SUBJECT: Collins Investments (File # SEG-06-44)

DESCRIPTION: Segregation of a 40.00 acre parcel into two 20.00 acre parcels.

PARCEL
NUMBER(s): 20-15-08000-0003

SUBJECT: Collins Investments Parcel Segregation 20-15-08000-0003

# RECORD OF SURVEY

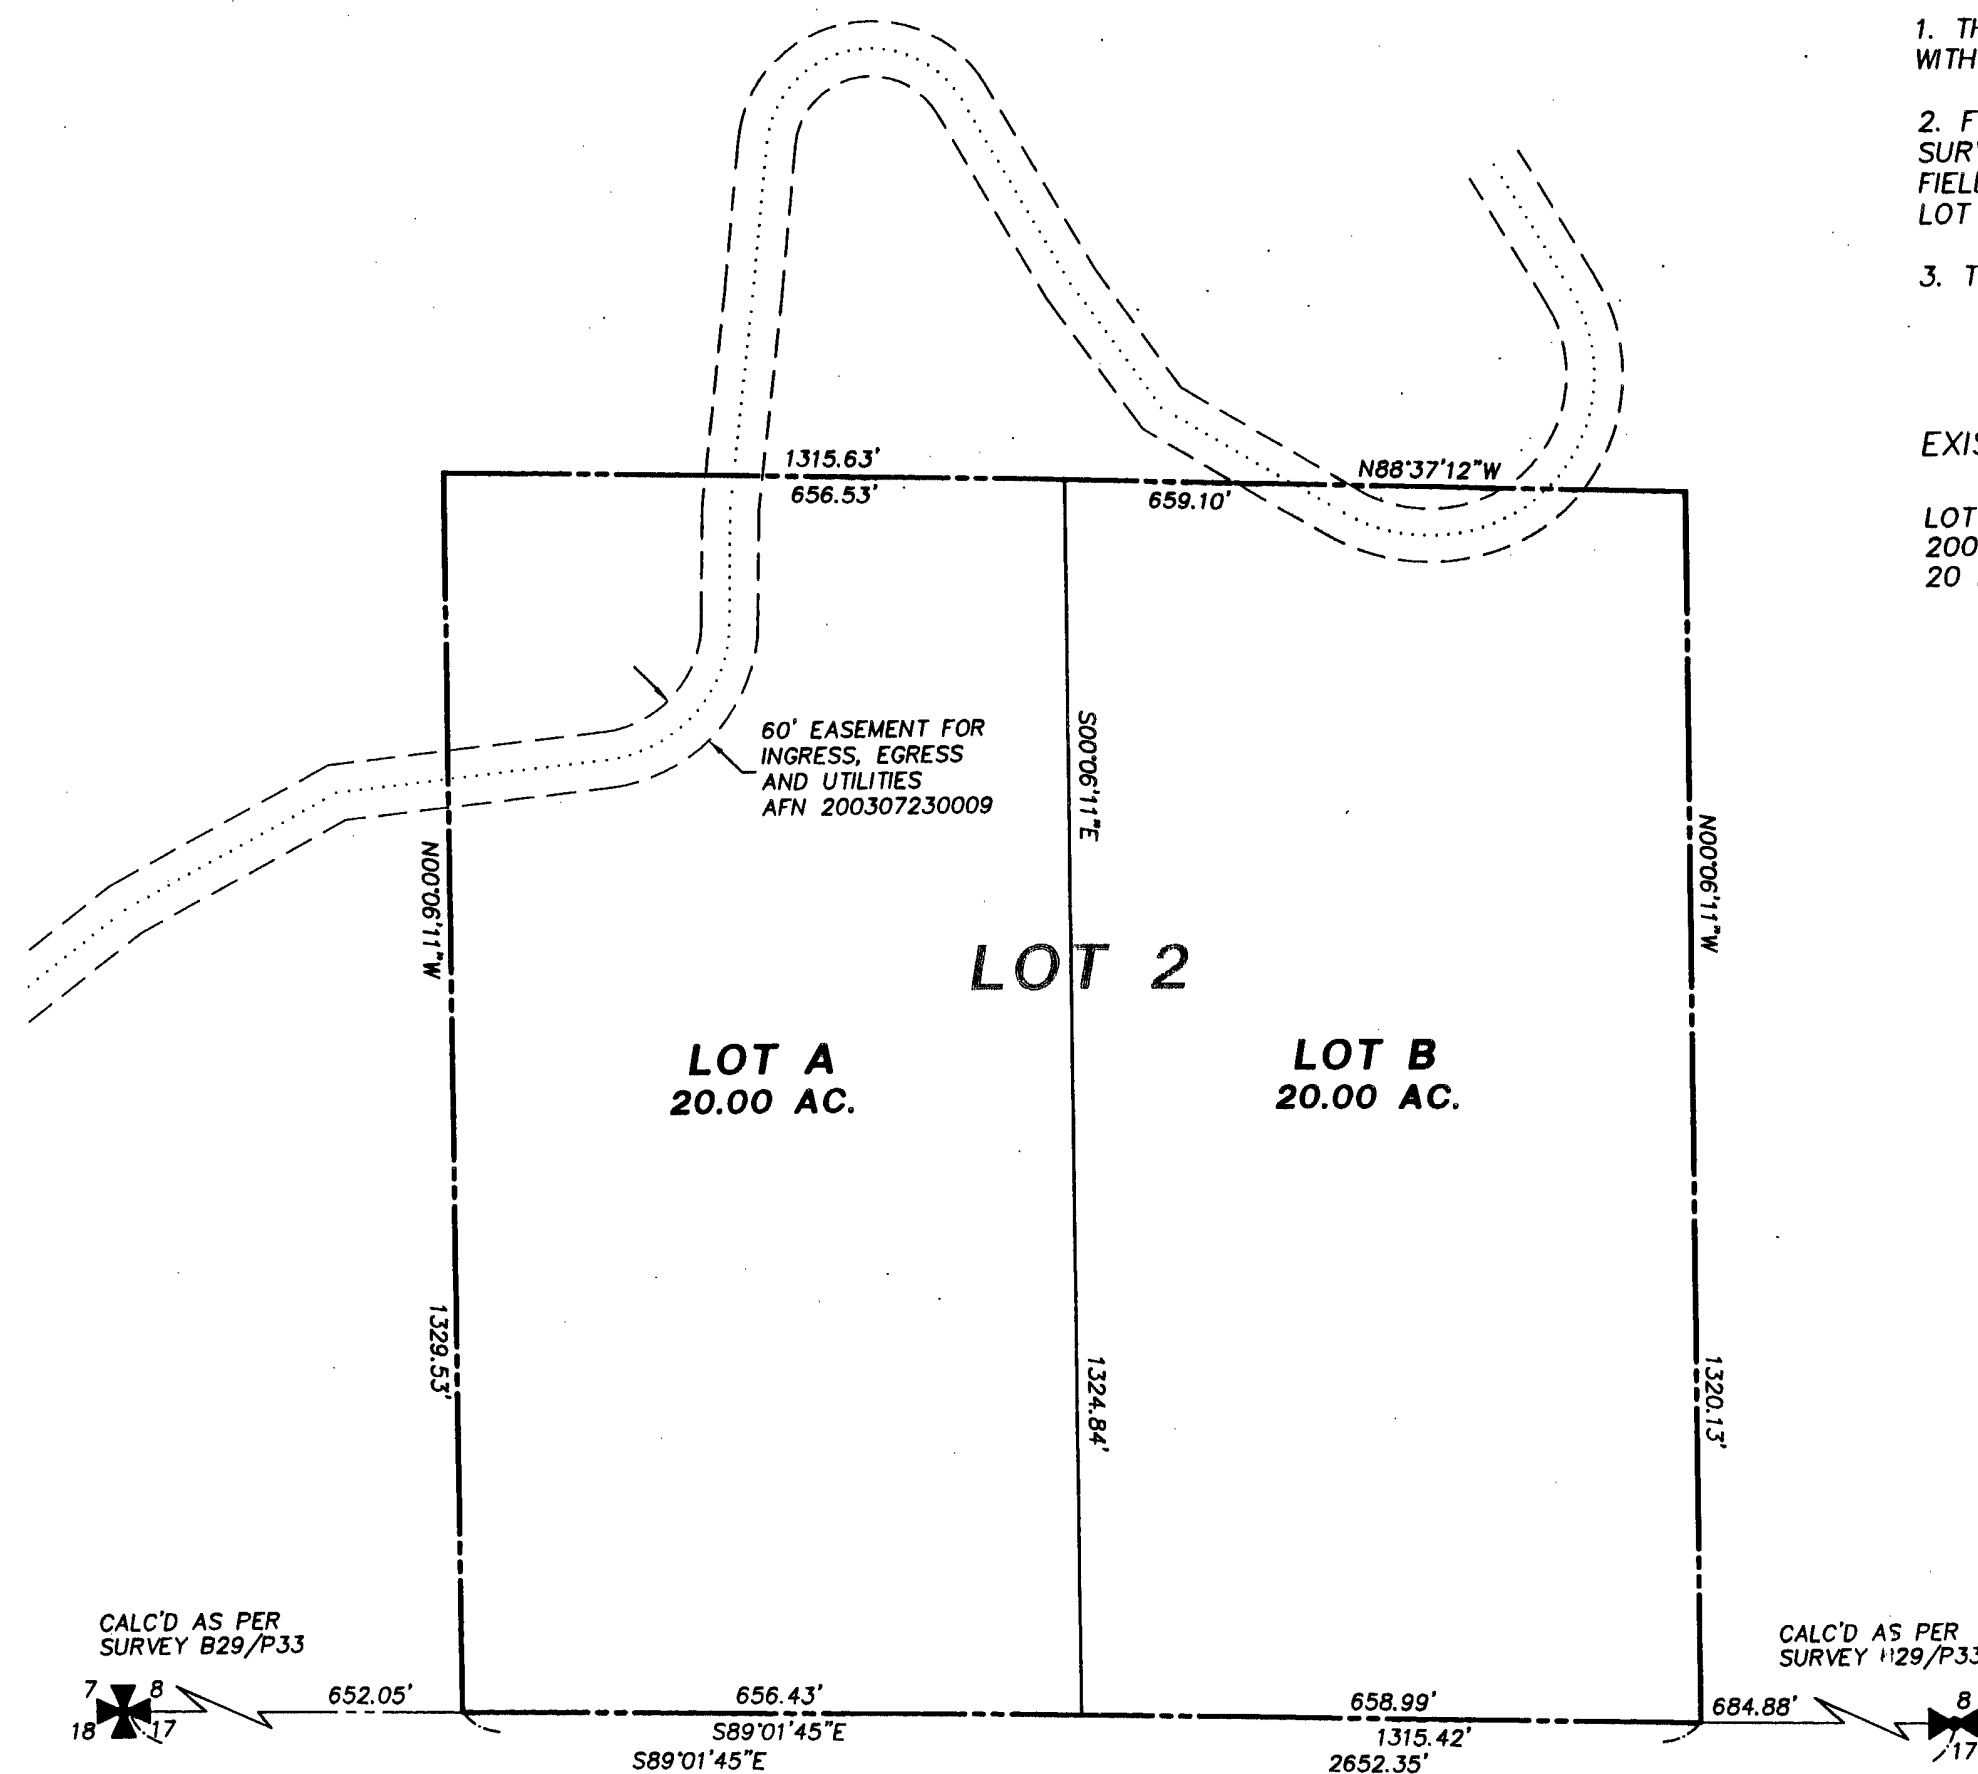
1. A survey of the proposed segregation must be received and approved.
2. Please see Kittitas County Public Works comment letter attached for additional information.

1. Prior to Final Approval the proposed access with appropriate easement(s) shall be shown and shall conform to applicable Kittitas County Road Standards.
